RE: Pitre KIA – Site Plan EPC

CONDITIONS OF APPROVAL-PR-2024-011052, SI-2024-01468 – Major Amendment to Site Plan – EPC

Per the conditions of approval dated November 21st, 2024, please find the following responses addressing the comments listed below:

City of Albuquerque  
Hydrology Section

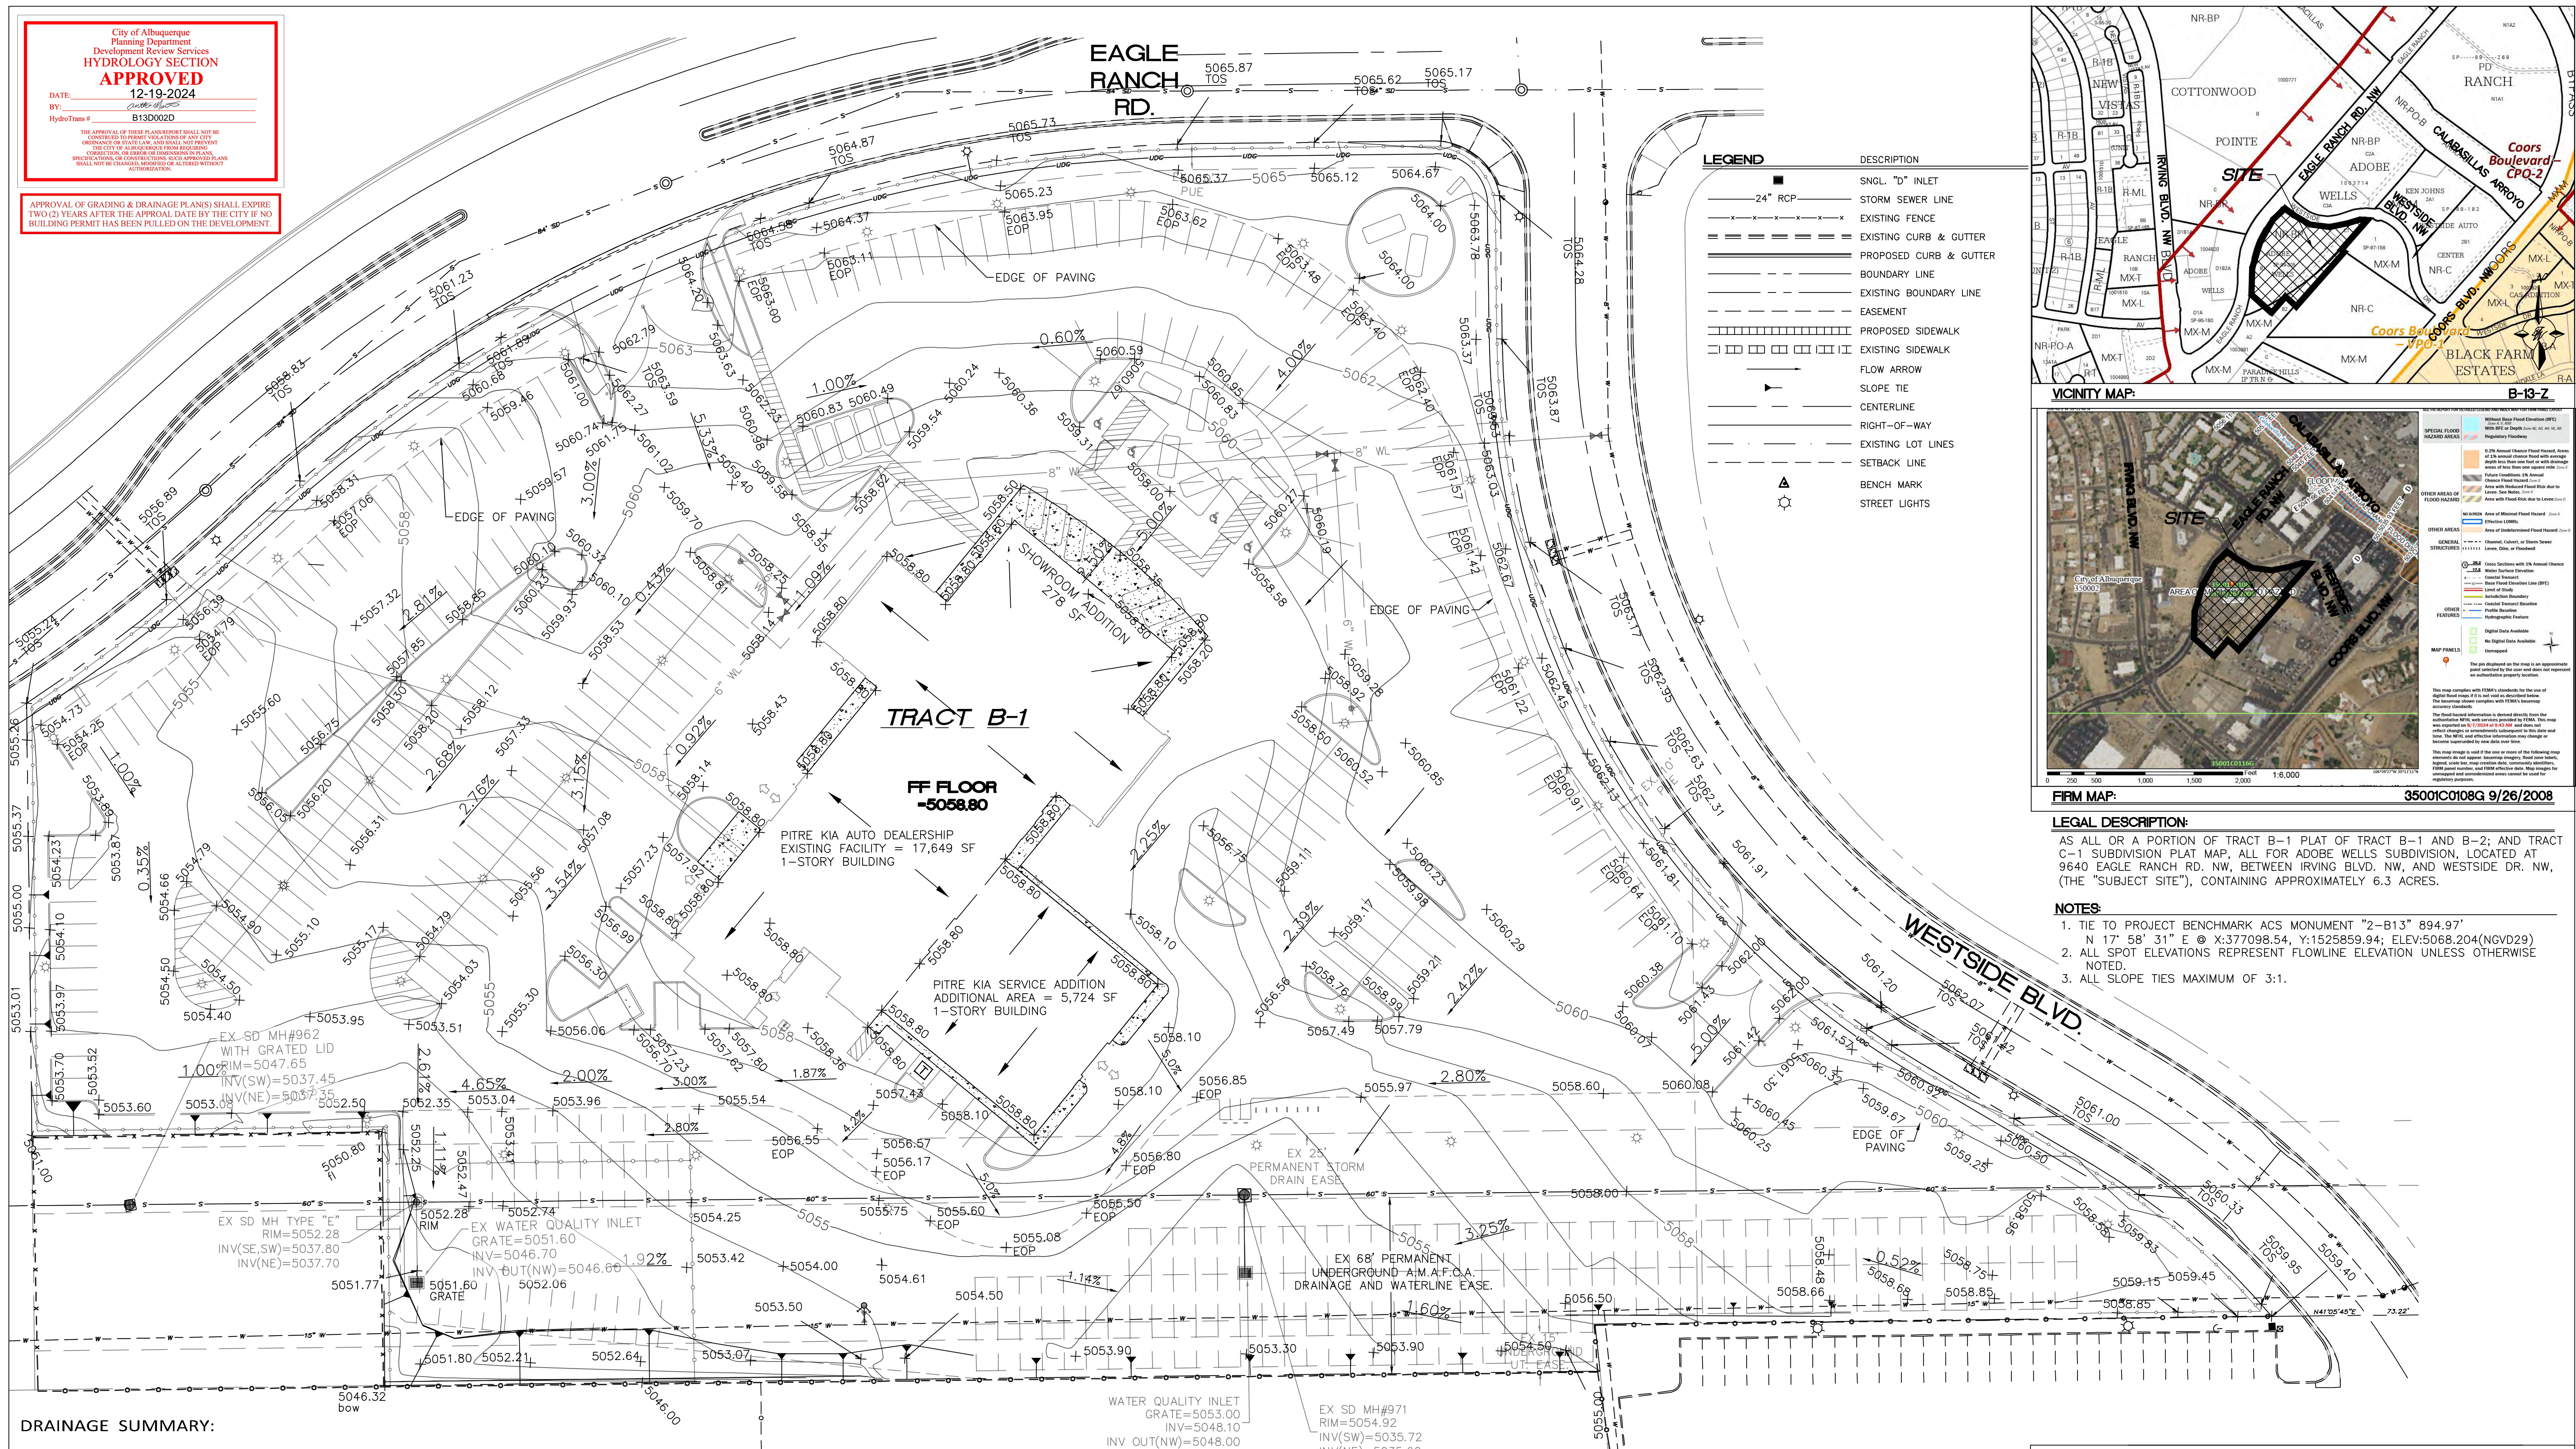
A Grading and Drainage Plan & Report must be approved by Hydrology prior to review/sign-off of the Site Plan by the DFT. Stormwater Quality Volume (SWQV) - The total required SWQV calculation must be included on the Grading and Drainage Plan along with Calculation of the portion of the SWQV for which payment-in-lieu is requested. Payment shall be made at the following steps in the City review/decision process:

Applicant Response: Hydrology approval received and attached to this response letter. All calculations referenced above can be found on the Grading and Drainage Plan as required.
